PLANNING APPLICATION REPORT**REF NO:** FP/109/11/**LOCATION:** 21 Uppark Way
Bognor Regis**PROPOSAL:** Erection of 1 No bungalow with associated parking and external works
(Resubmission of FP/241/10/)**SITE AND SURROUNDINGS**

Project Land Adjacent 21 Uppark Way **Drawing Title** Planning **Drawing No** 508/DPA02 **Rev** 04

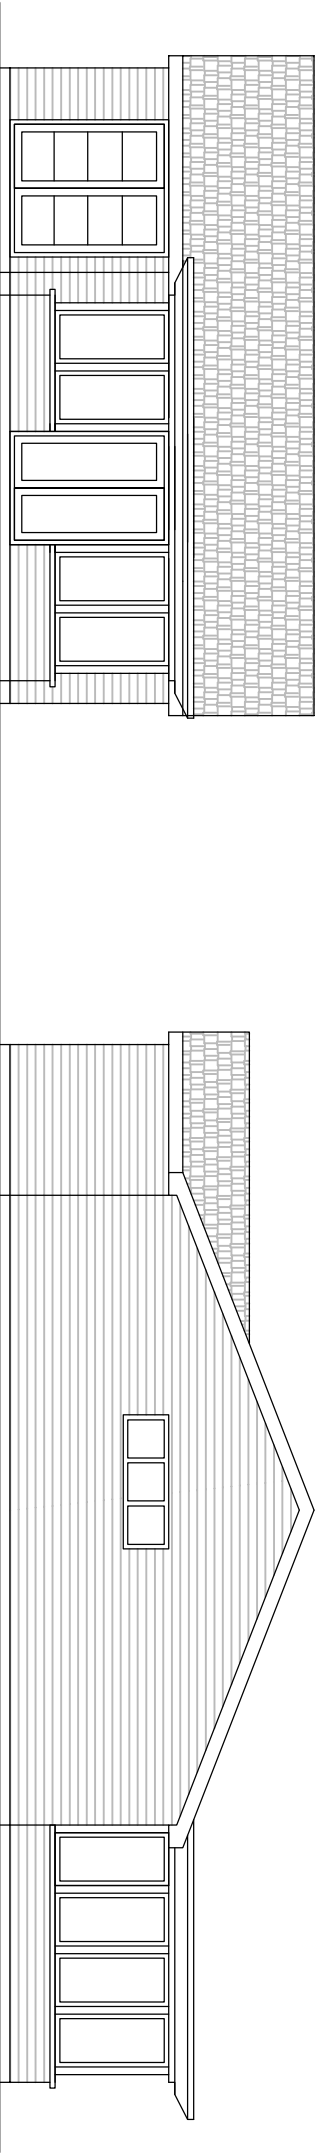
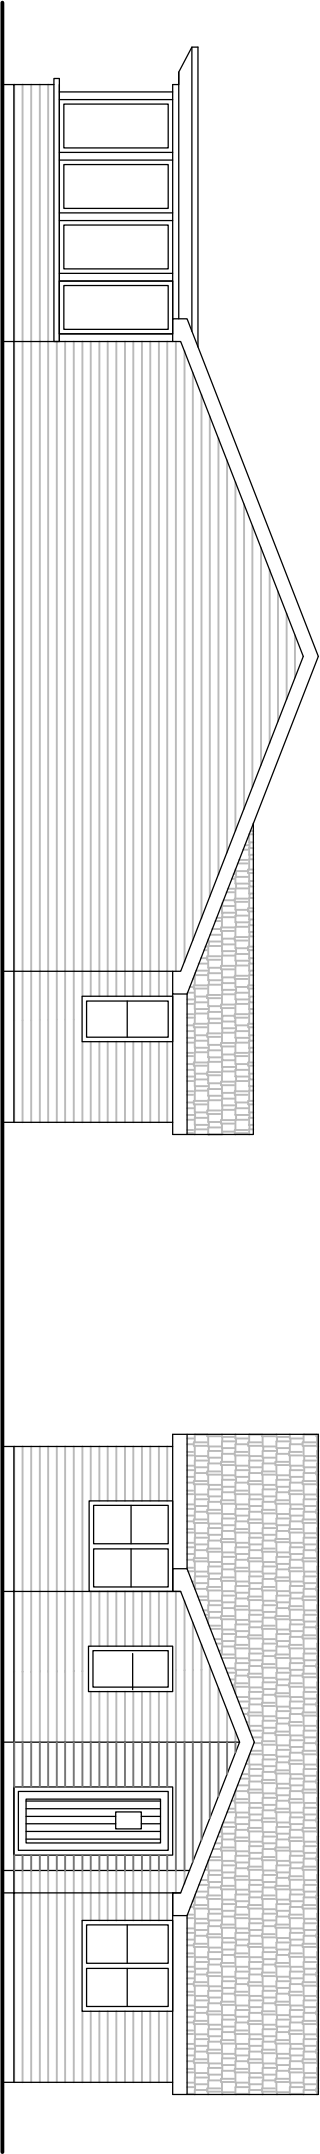
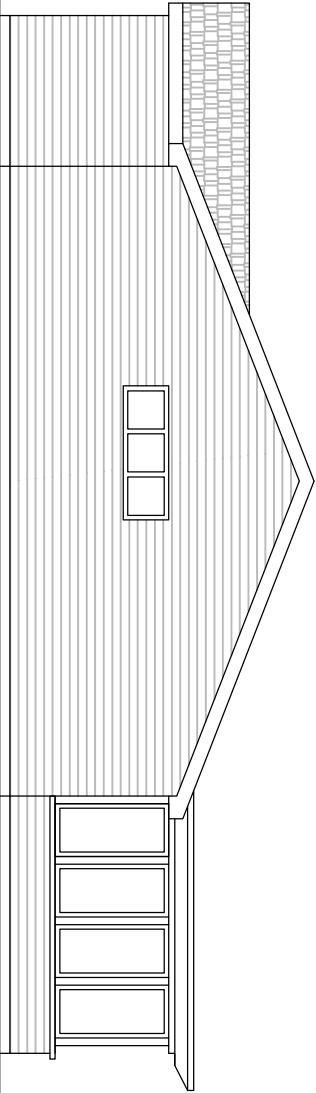
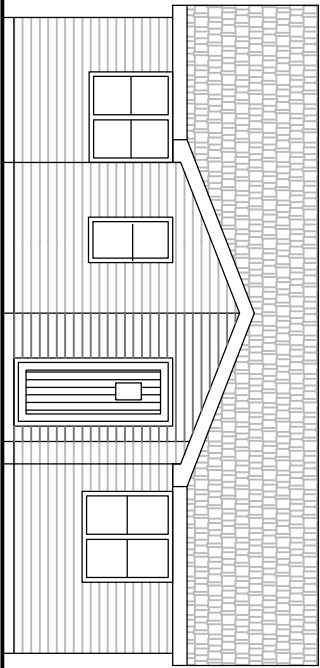
The dwelling has been designed to avoid any potential overlooking with no first floor side windows. Therefore it is not considered that the proposal would result in any significant loss of residential amenity.

PROPOSED SITE AND ROOF PLAN

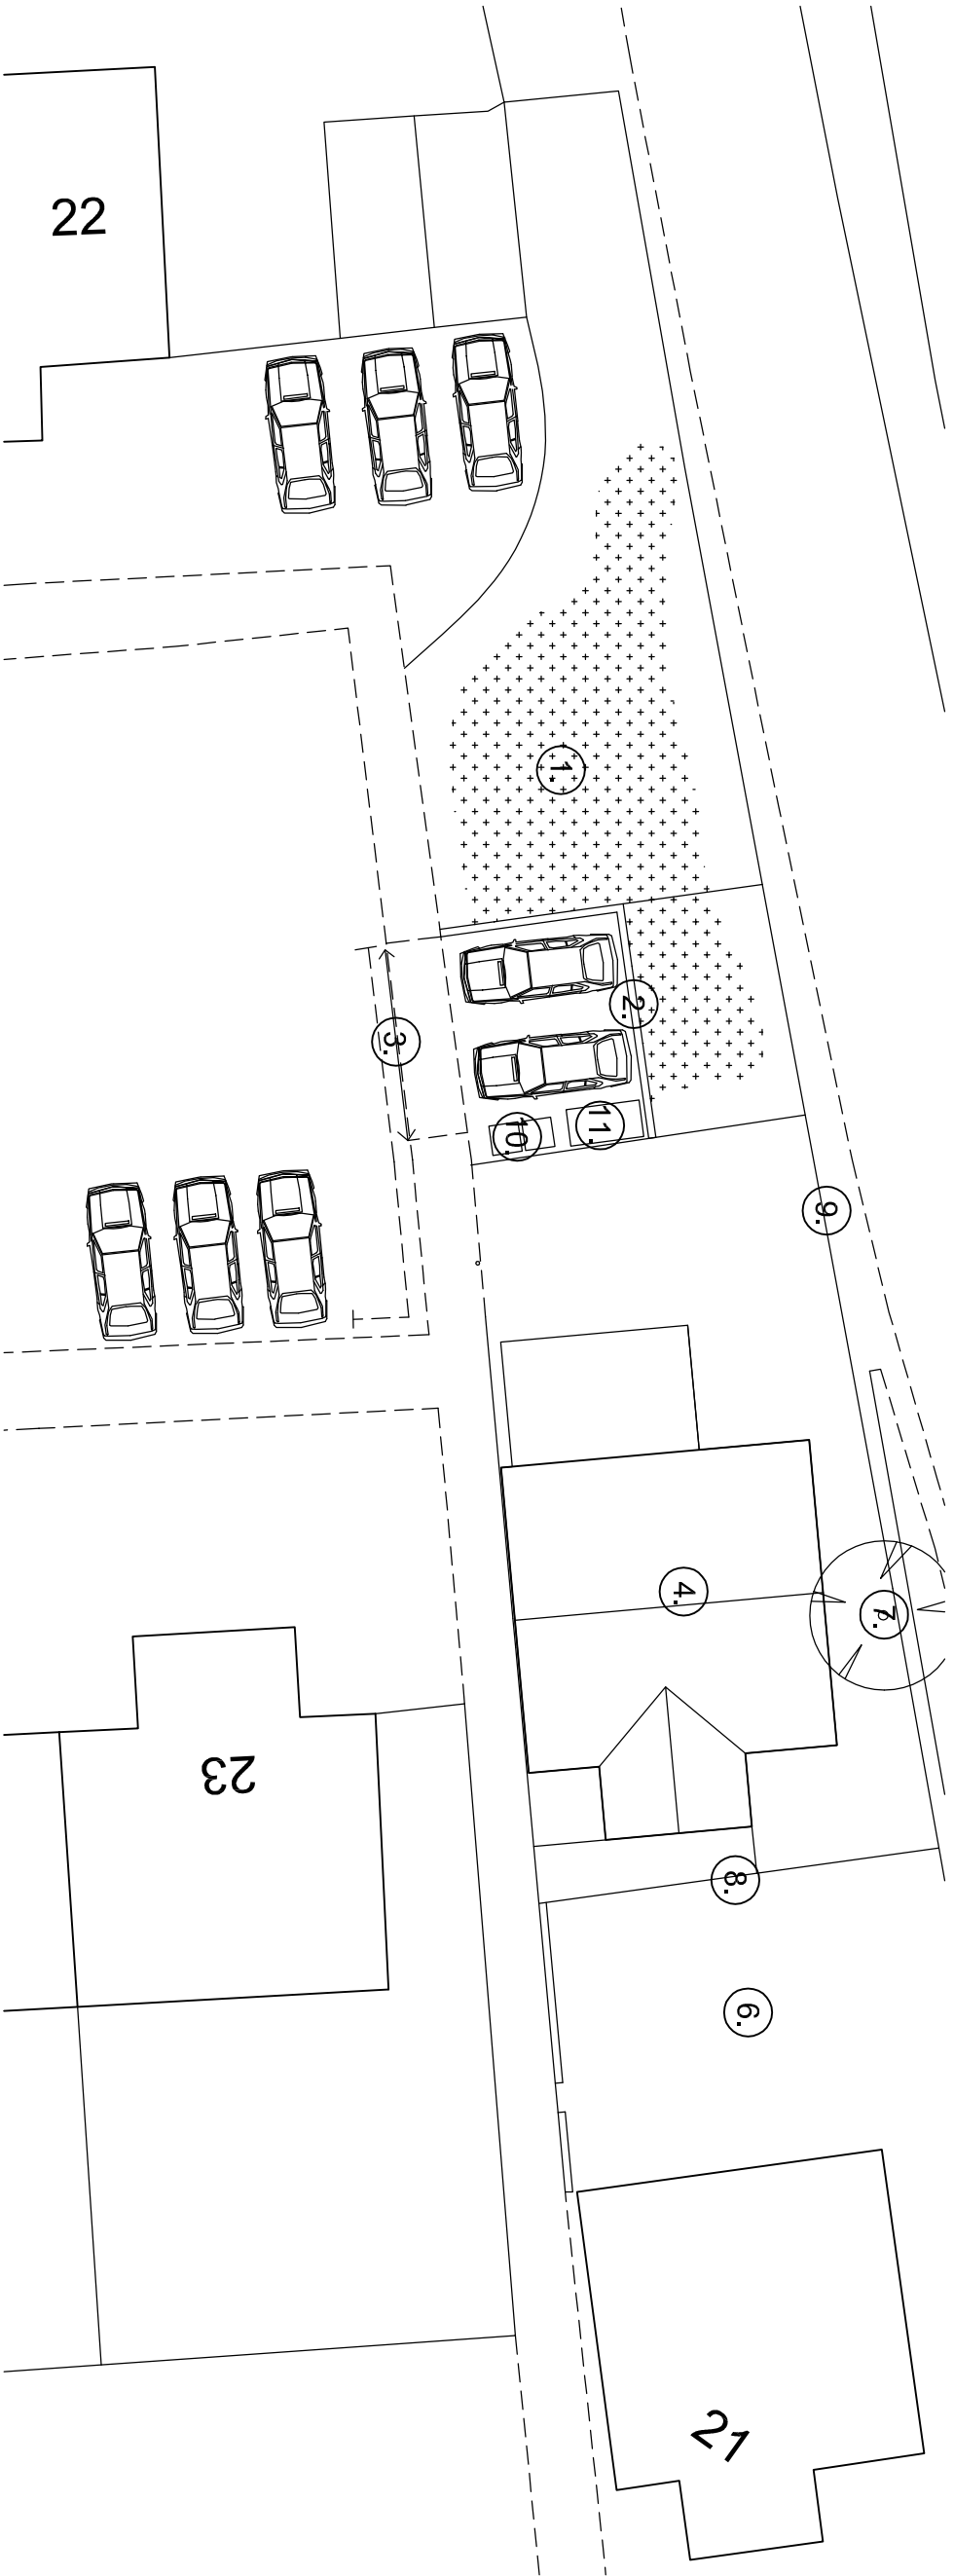
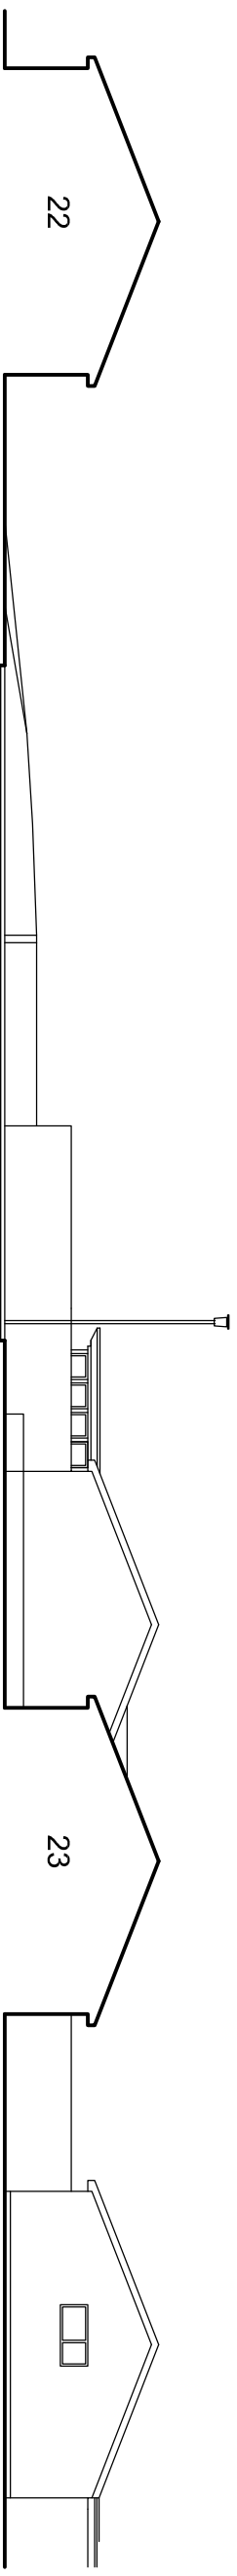
Southern Water - No objection in principle. There is a public sewer on site which will need to be located exactly with no development to take place within 3.5m either side of the sewer.

The proposed layout is furthermore not in keeping with the character of the area with the gable end facing the road and the front door to the side.

County Highways has raised no objections, however, they require details of visibility splays to be submitted. The proposal results in the loss of a garage and car parking space for the existing dwelling.
